70047808-IT1-LTR-001

24 August 2018

94 - 100 Hook Lane, Bognor Regis

FLOOD COMPENSATION AREA

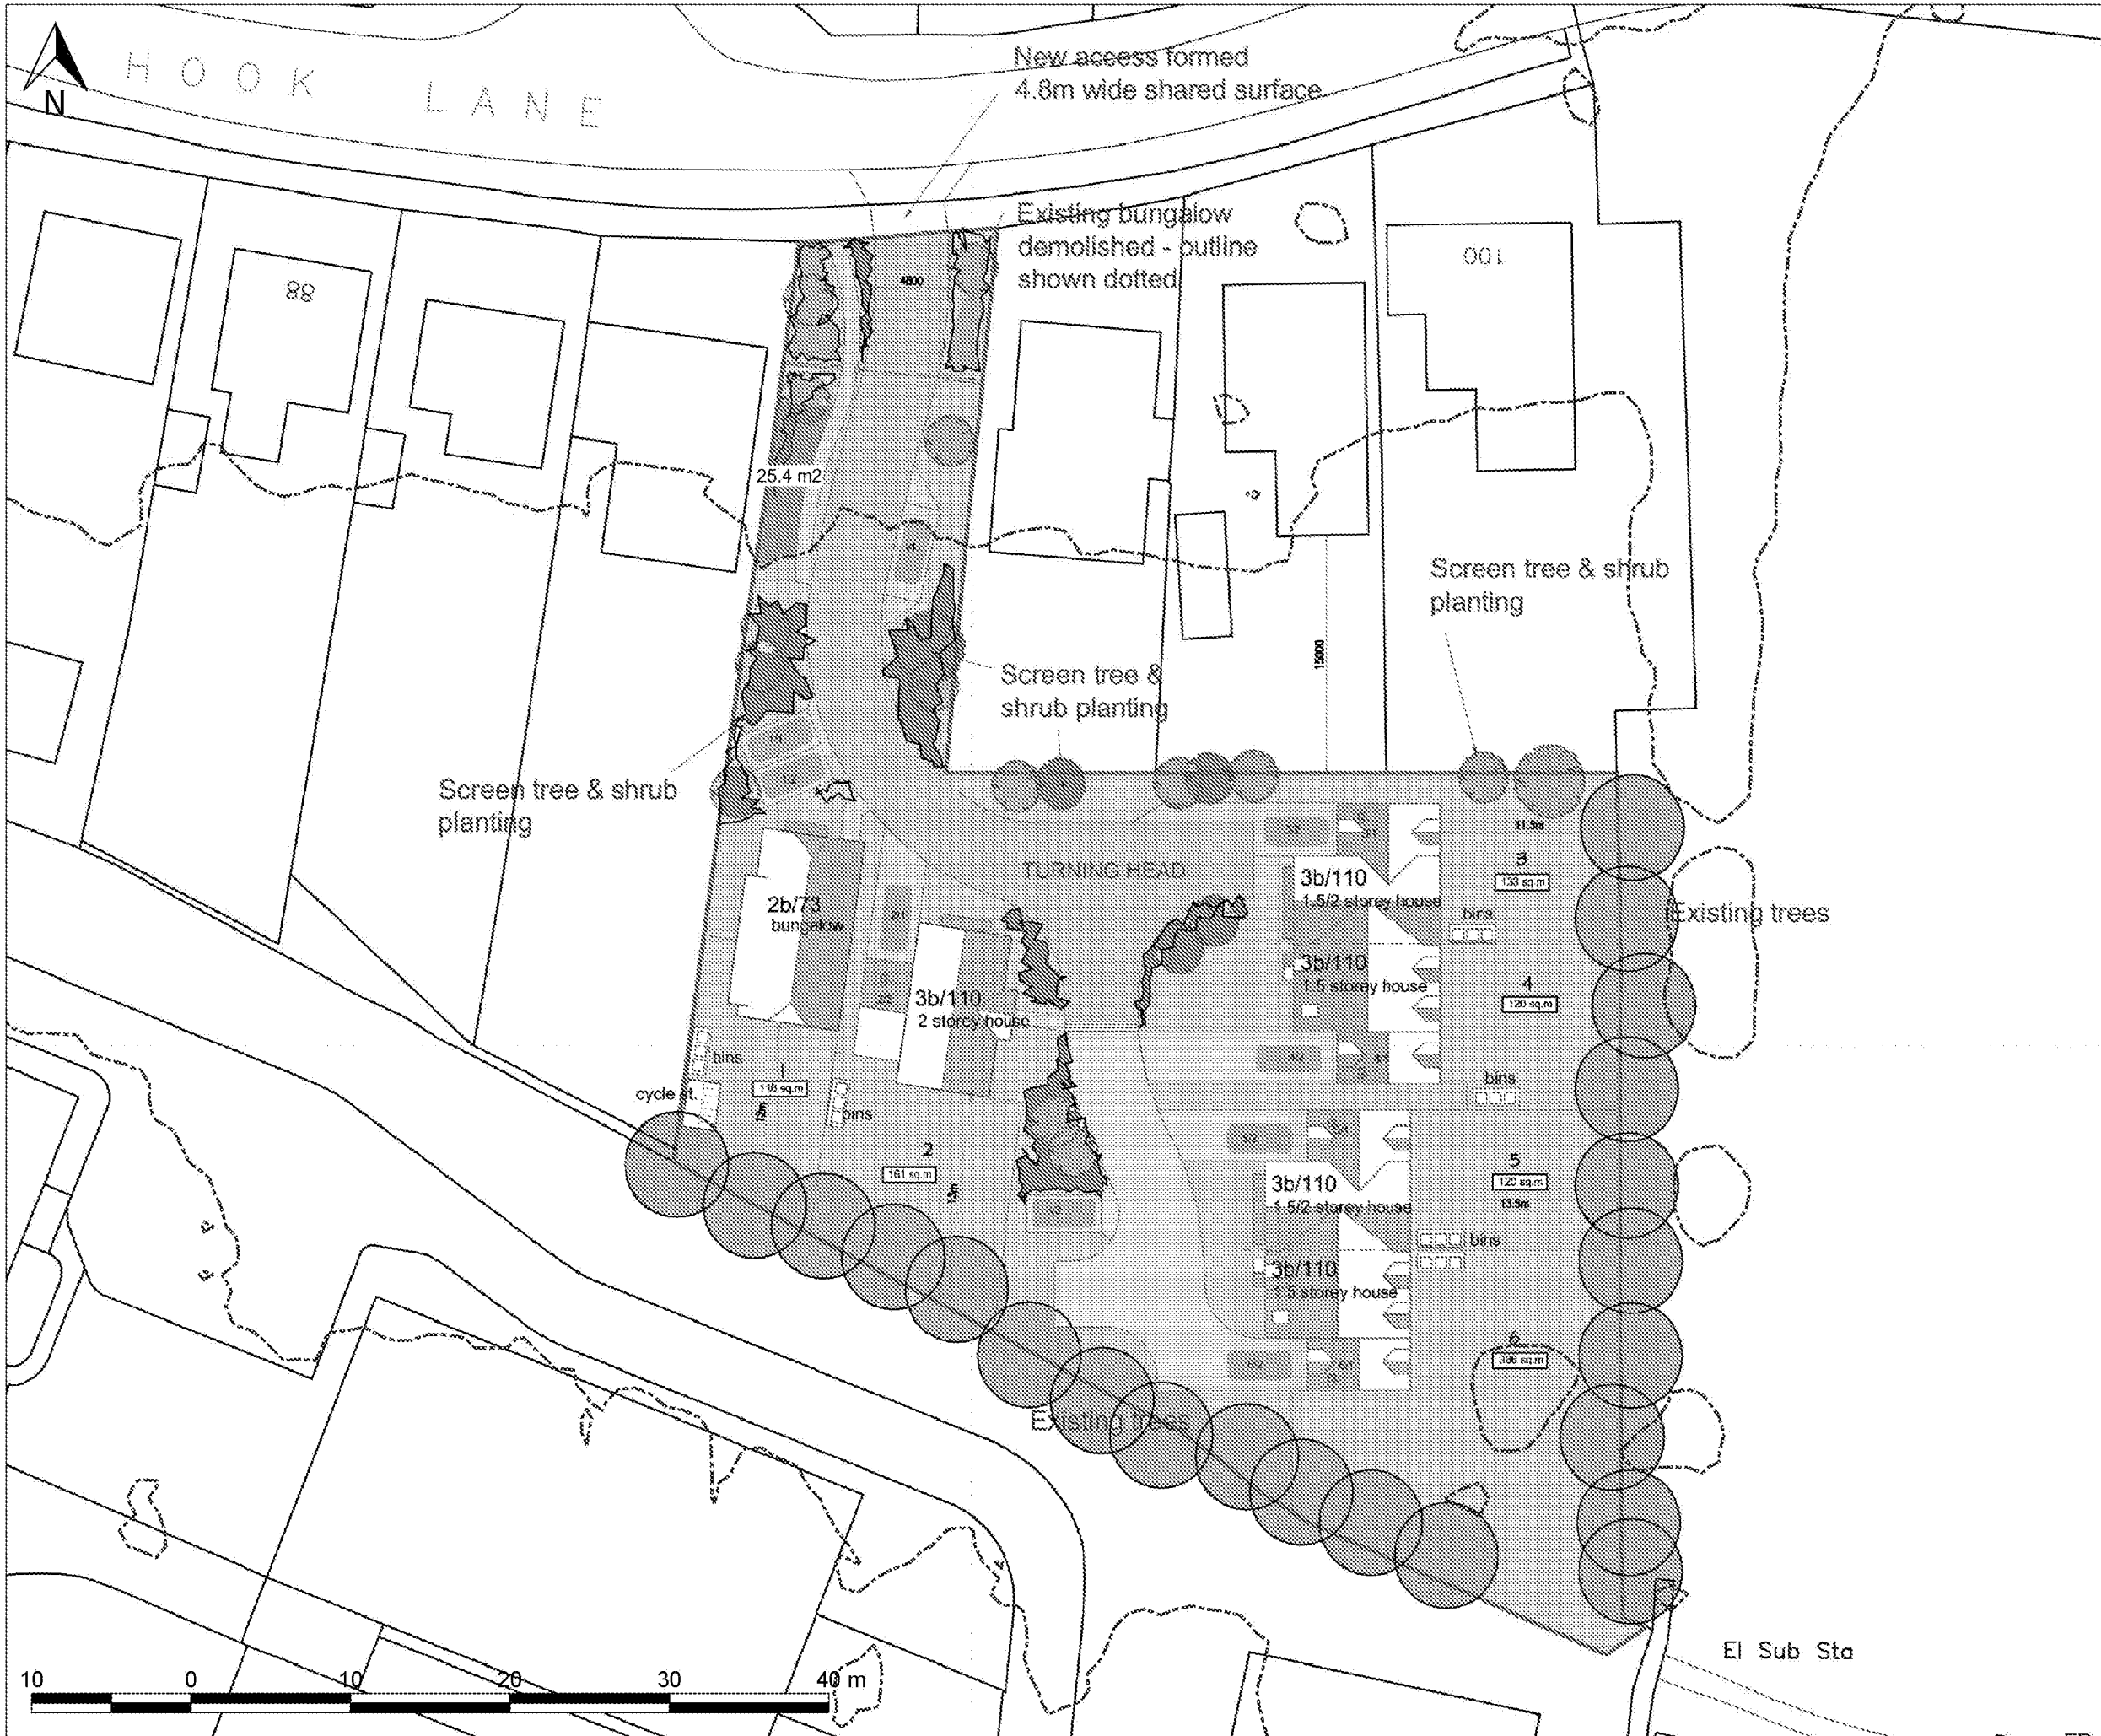
Objection 3: More information about the proposed flood compensation is needed. Basic requirements for compensatory floodplain storage are as follows

- ③ A volume of floodplain equal to or larger than that lost to the proposed development must be created.
- ③ The volume must apply at all levels between the lowest point on the site and the design flood level. Normally this is calculated by comparing volumes taken by the development and the volume offered by the compensatory storage for a number of horizontal 'slices' through the range defined above.
- ③ The thickness of a vertical slice should typically be 0.2 metres. In the case of large flat sites or very steep sites this may be varied, for example for flat sites to 0.1 or even 0.05 metres. The slice thickness should be set to provide between ten and fifteen slices for such unusual sites

Response: As discussed, the current calculations have been based on assumptions regarding the number of piers and the size of the piers per property. It was agreed that following detailed design the floodplain compensation calculations would need to be revisited, and these would need to be informed by suitable geo-technical investigations.

The estimated total area of the piers equals 5.76m² (450mm diameter piers, 6 No. piers per building; 6 No. buildings at the Application Site)

For each 200mm vertical increase, the piers will displace a volume of water which equals 5.76*0.2=1.15m³

To achieve an increase in floodplain storage, a 20% allowance has been accounted for in the floodplain compensation indicative area. The FRA demonstrates that the northern part of the site, near Hook Lane access, can be used as flood compensation (refer to attached Drawing 47808-FCA-001).

Level	Volume lost (m ³)	Flood compensation area required (m ²)	Flood compensation area identified (m ²)	Flood compensation volume identified (m ³)
1.3 m AOD to 1.5 m AOD	1.15	5.76	7.06	1.41
1.5m AOD to 1.7 m AOD	1.15	5.76	7.06	1.41
1.7 m AOD to 1.9 m AOD	1.15	5.76	7.02	1.41
1.9 m AOD to 2.1m AOD	1.15	5.76	7.07	1.41
2.1 m AOD to 2.19m AOD	0.52	2.6	9.60	1.92

The volume required to achieve the flood plain compensation vertical strip between 1.3 and 1.5m AOD will be achieved in the area specified. It is anticipated that localised reprofiling of the Site will be required to facilitate hydraulic connectivity between the floodplain compensation and the source of flooding.
